PREFERRED PROJECT REPORT
MP 10_0171

330 CHURCH STREET, PARRAMATTA

JULY 2012

A501

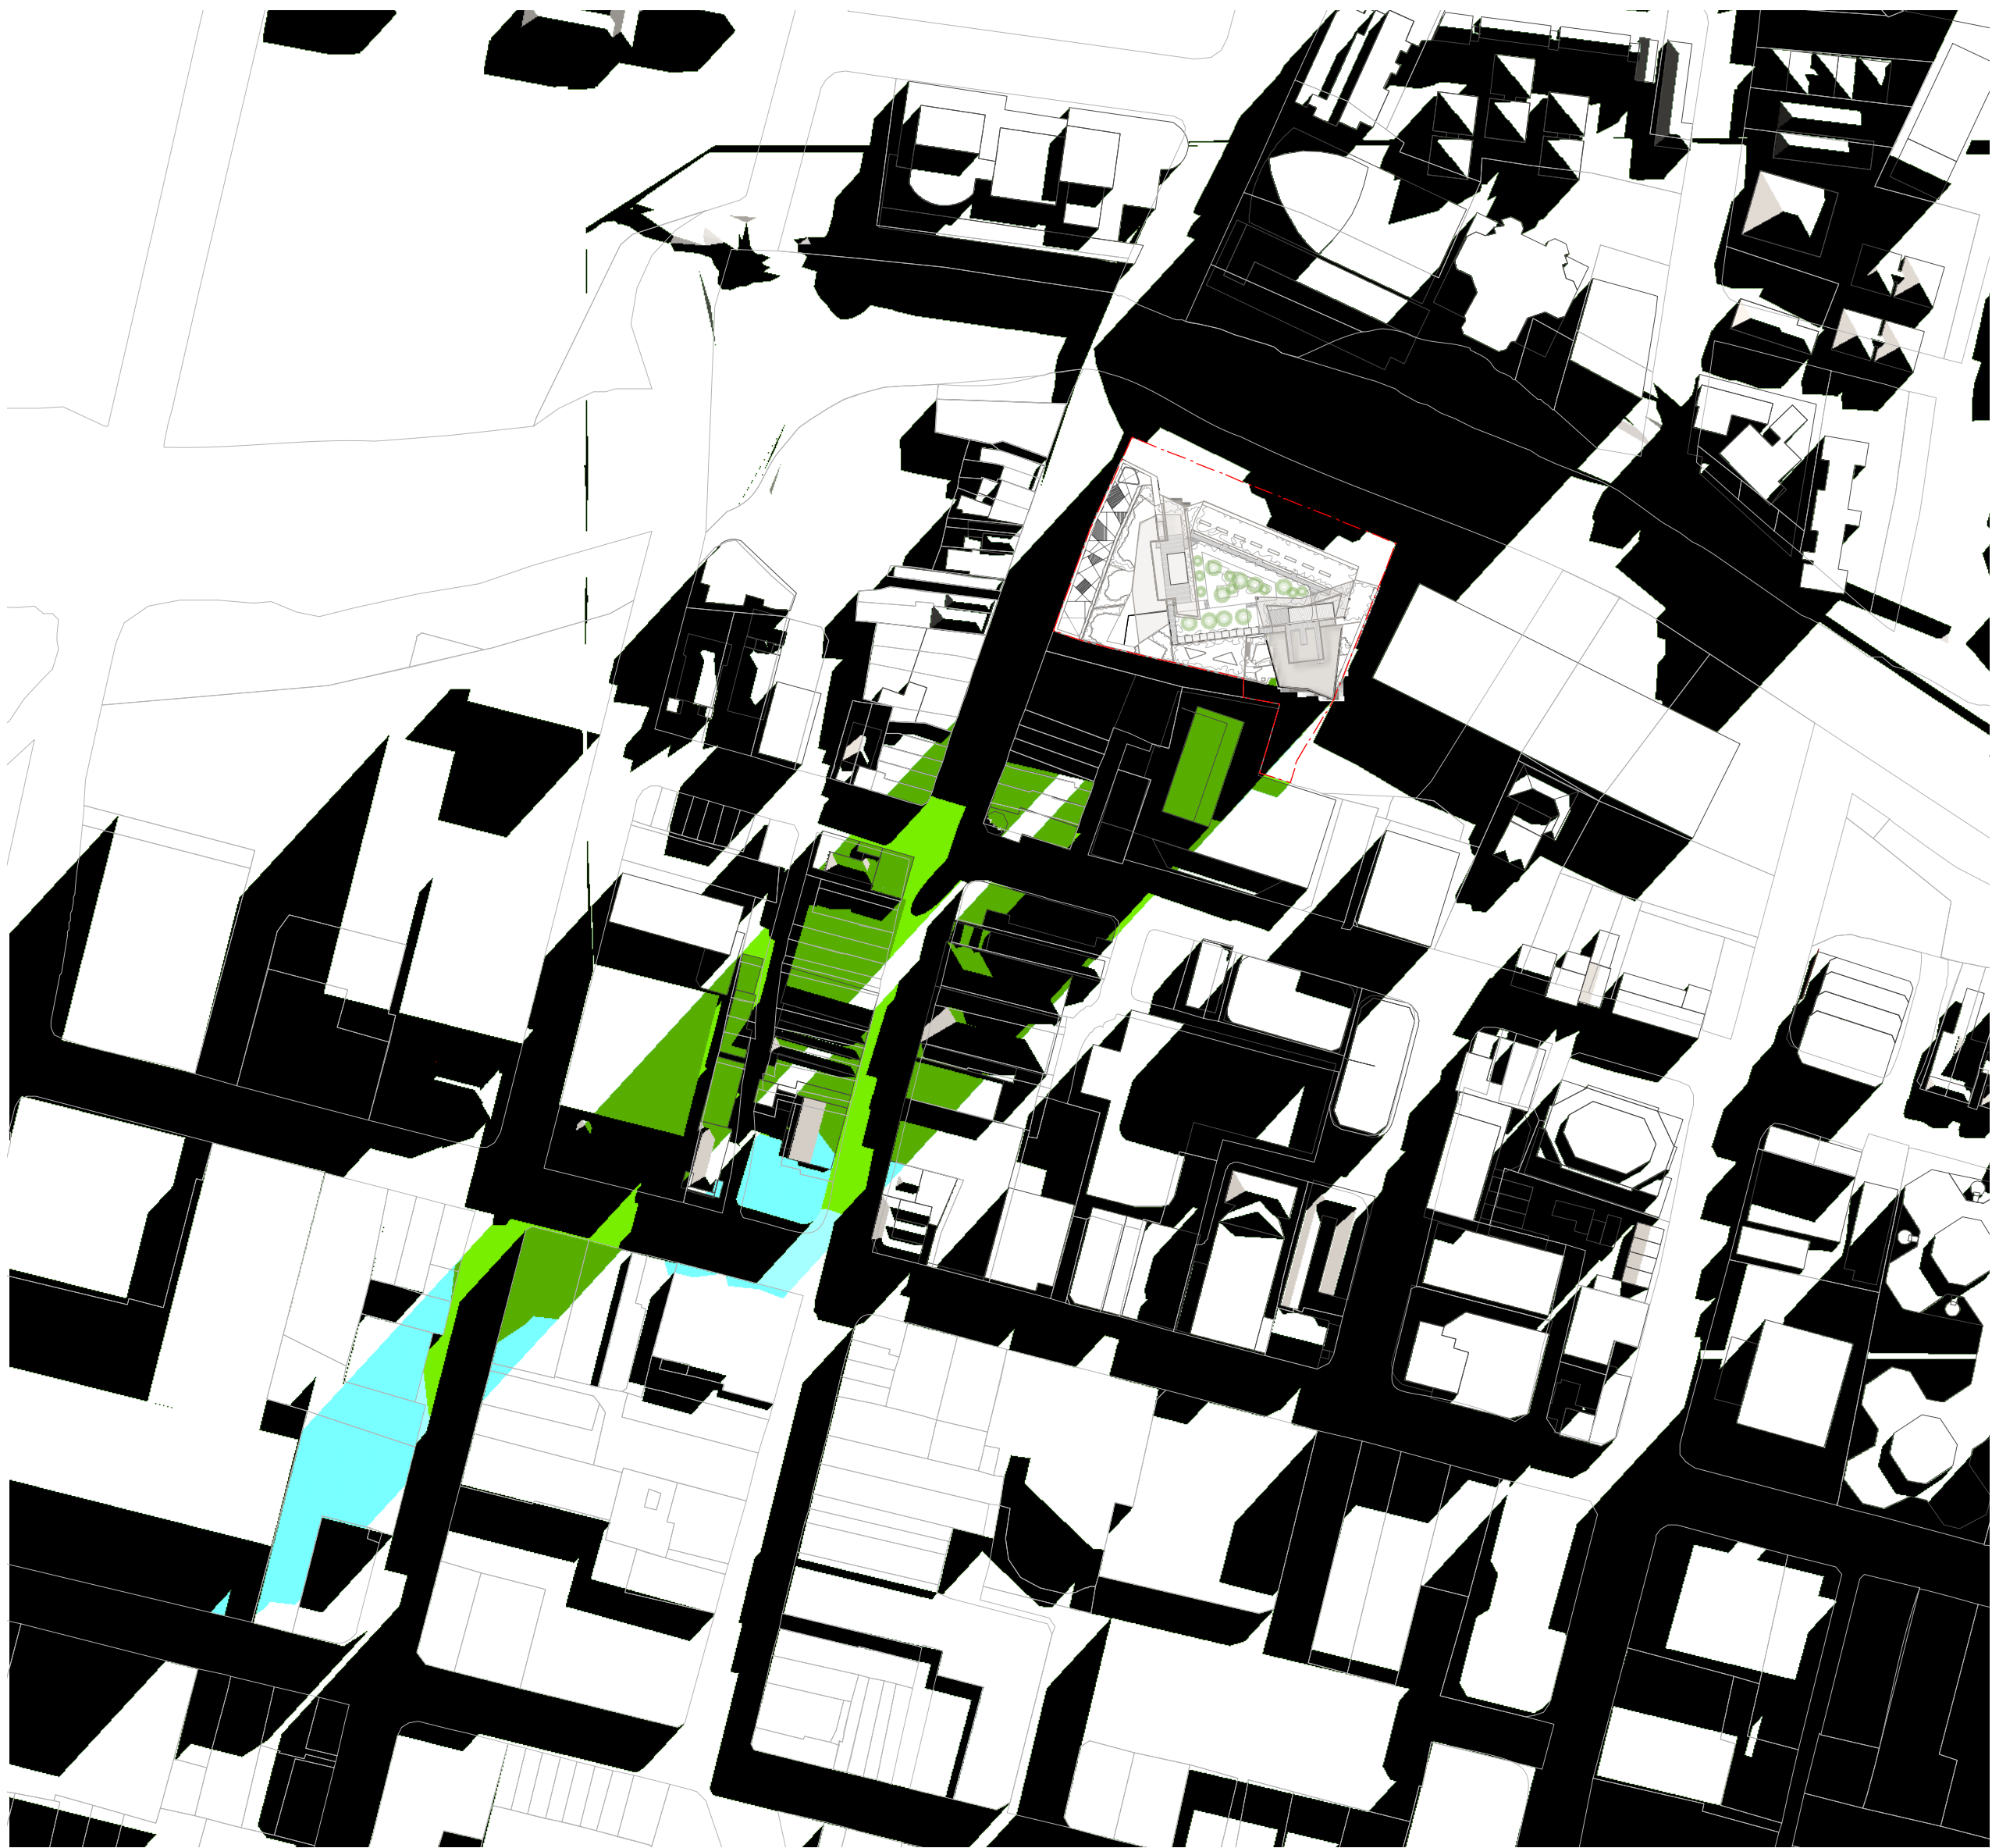
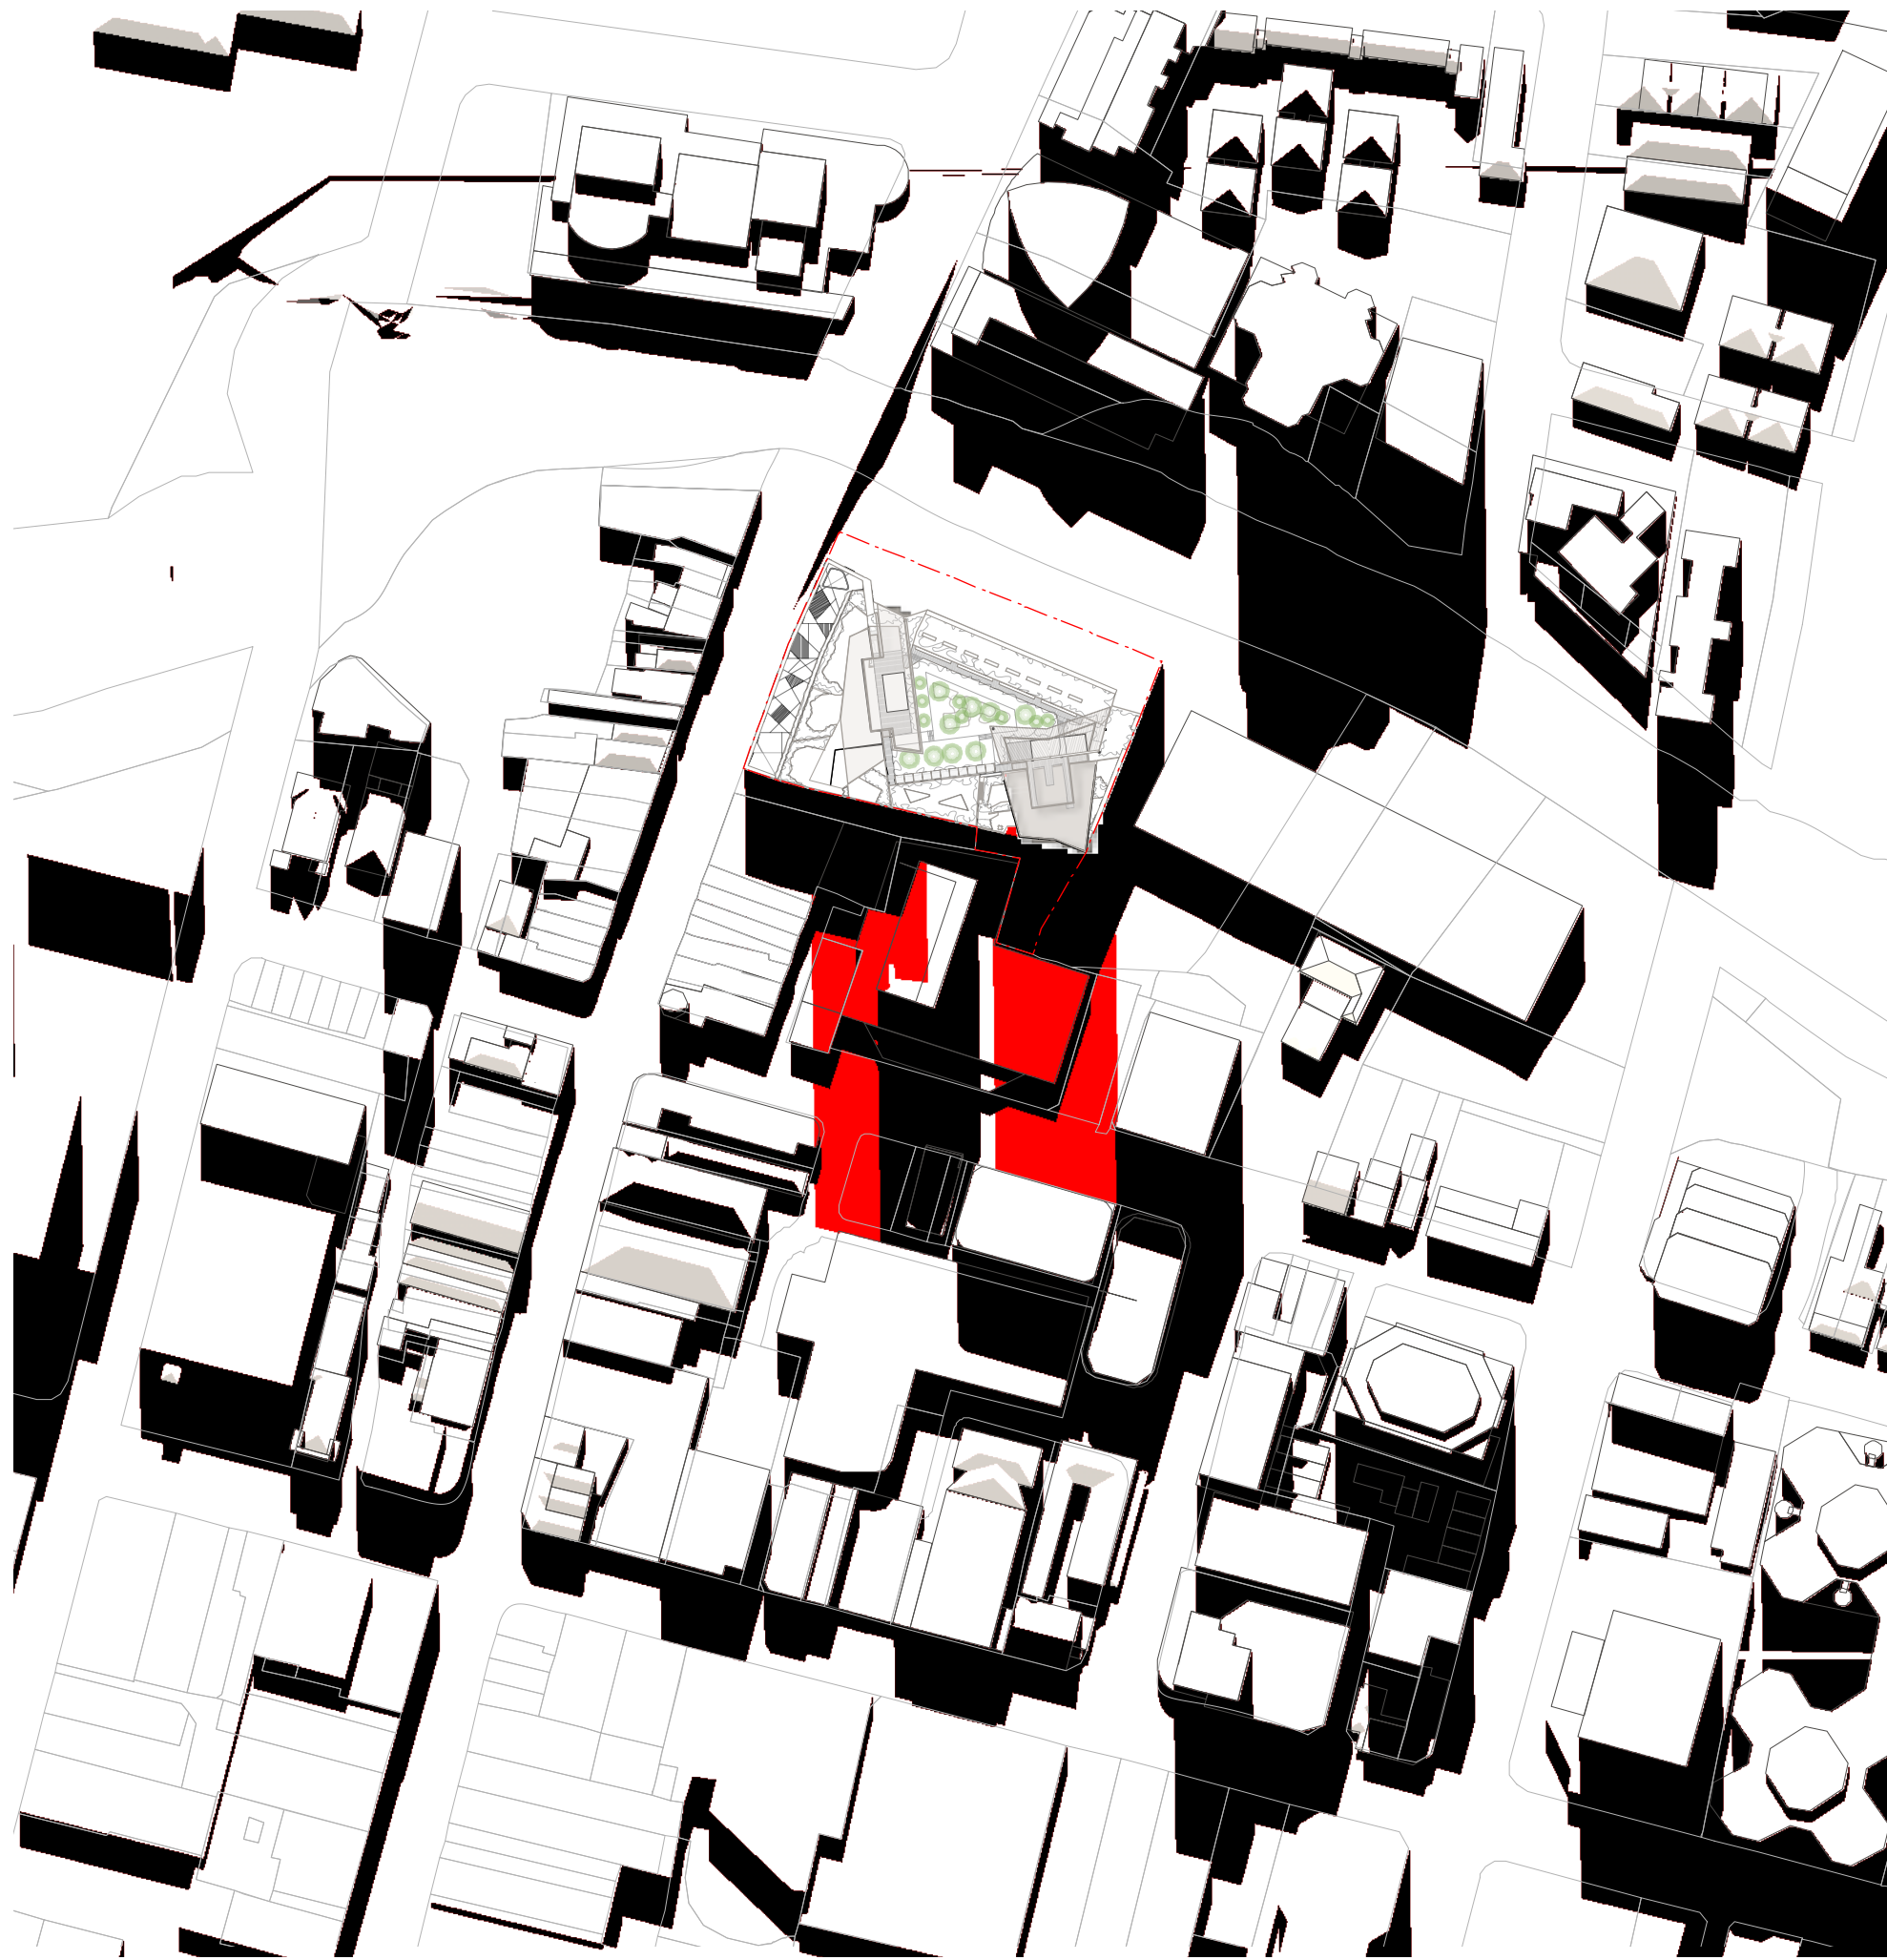
Shadow Diagrams

The architectural plans have been amended to include shadow diagrams providing a comparison between the existing building, a compliant development (built to the current height maximum and incorporating the setbacks specified in the Riverbank Site Controls) and the proposed development. This is now shown on plan A500 and A501. The amended architectural plans are at Annexure 3.
